# CITY OF ALBUQUERQUE

**Re: Cool Springz Trampoline Park  
Erosion and Sediment Control Plan  
Engineer's Stamp Date 5-17-17 (F17E095B)**

Based upon the information provided in your submittal received 5-19-17, the above referenced plan is approved to be included in the SWPPP and to apply for an ESC Permit for grading and Building Permit with the following condition:

Erosion Sediment Control Plan

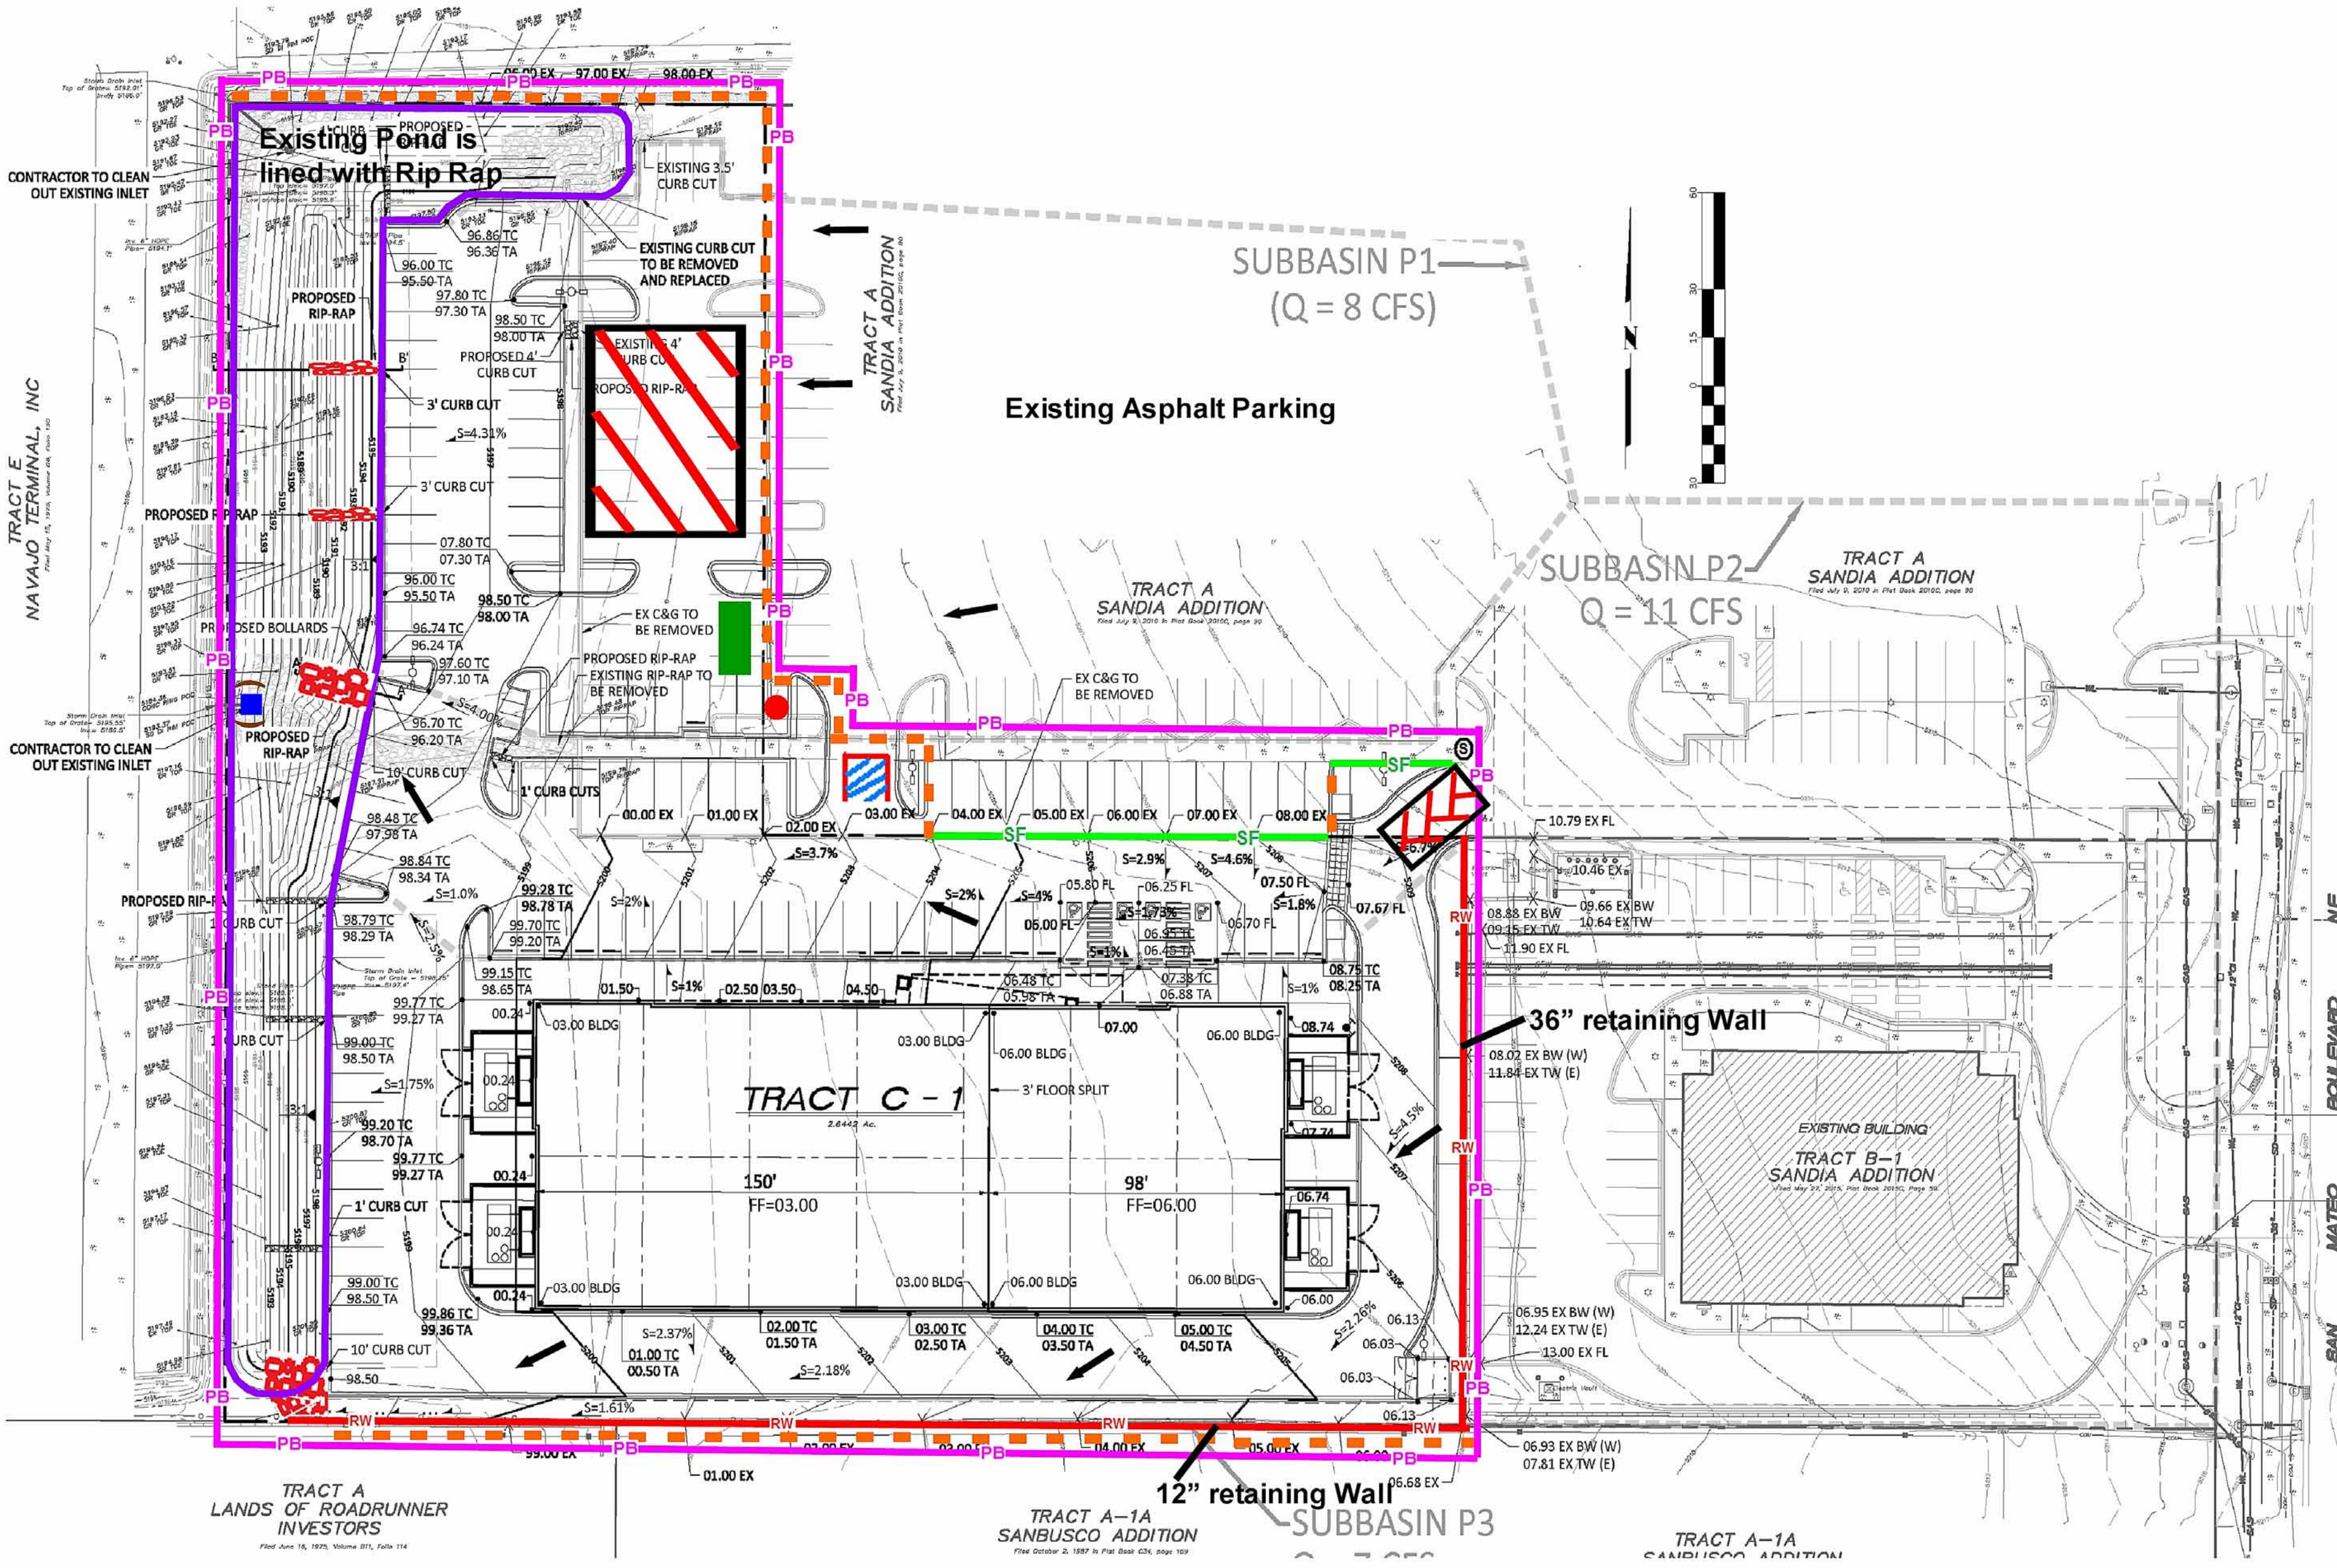
The inlet in the bottom of the pond at the north end should have the same inlet protection as the inlet in the middle of the pond.
